August 9, 2022

Reference: Engineering Services
422 Wade Stewart Circle
Lillington, NC 27546
Project No.: DRB2201-0048-B

As requested by the client, Tyndall Engineering & Design (TE&D) made a site visit to provide analysis for the following item(s):

- 1) Hanger specifications for (2) 1-3/4" x 9-1/4" LVL beam that is not fully bearing at column at rear porch.

FIRST FLOOR PLAN

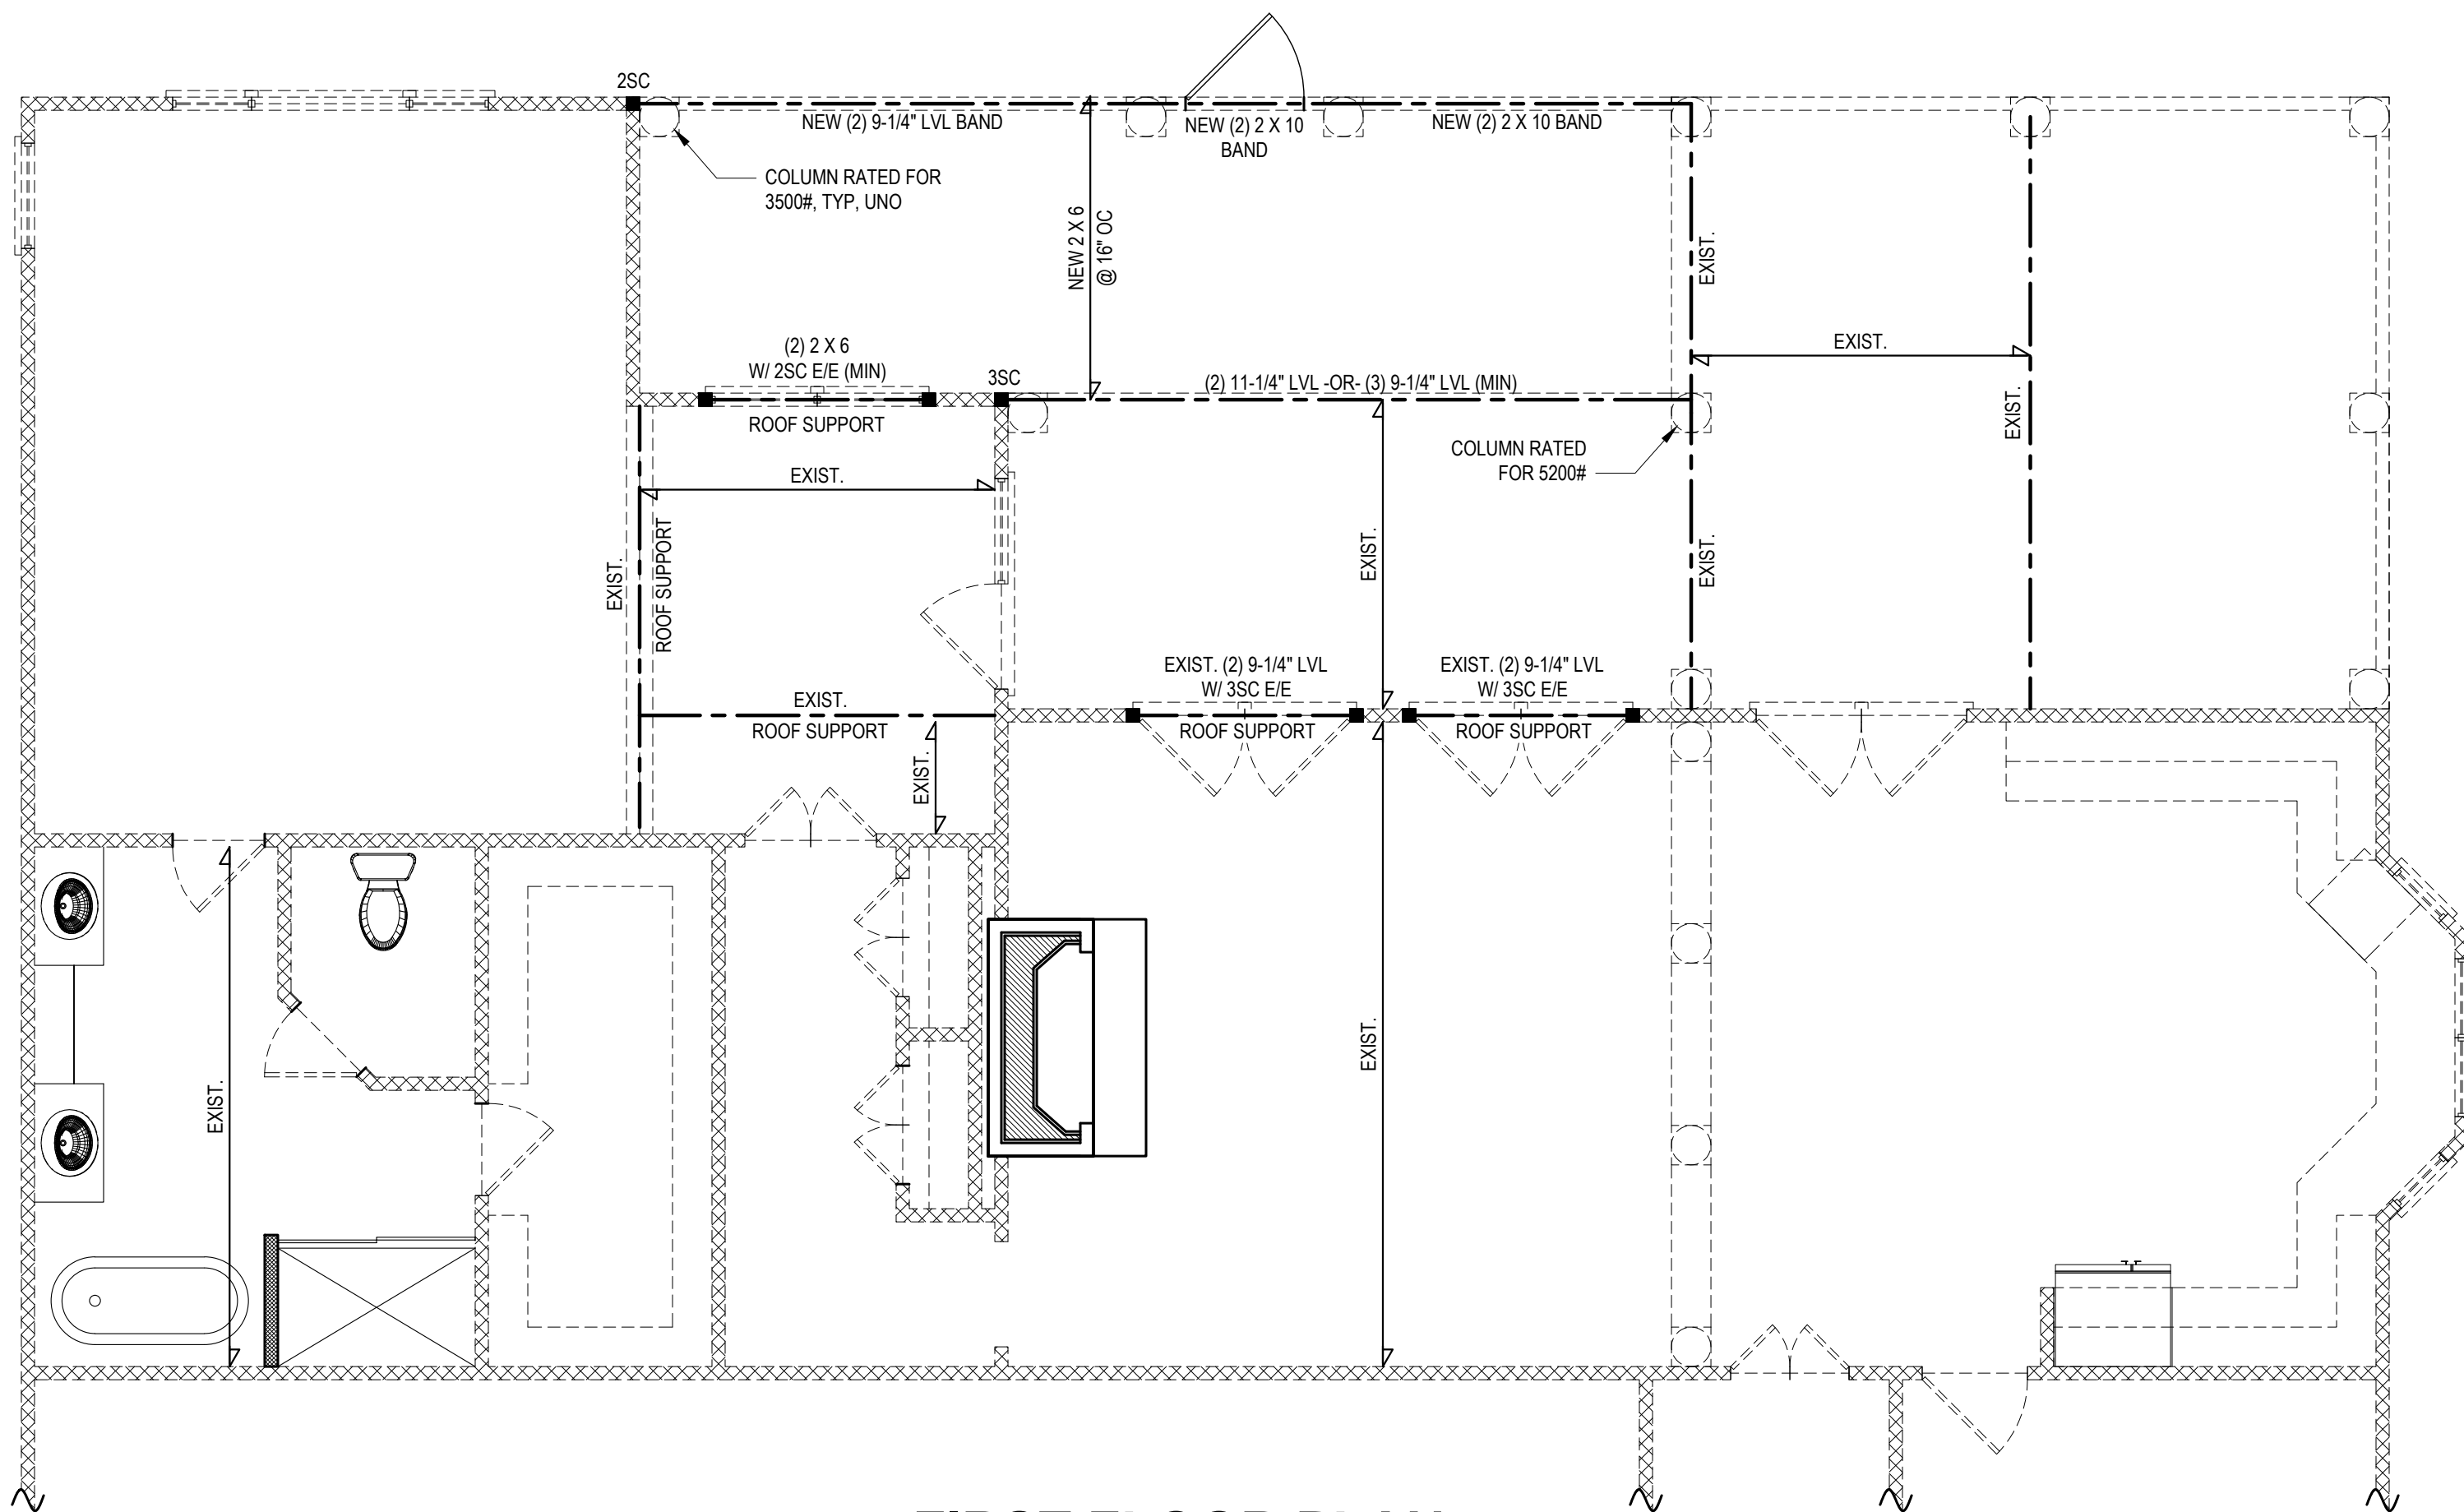
- 1) Based on our observations and analysis, TE&D recommends that the (2) 1-3/4" x 9-1/4" LVL beam be fastened to the existing beam with a new Simpson LS90 angled bracket per the manufacturer's specifications.
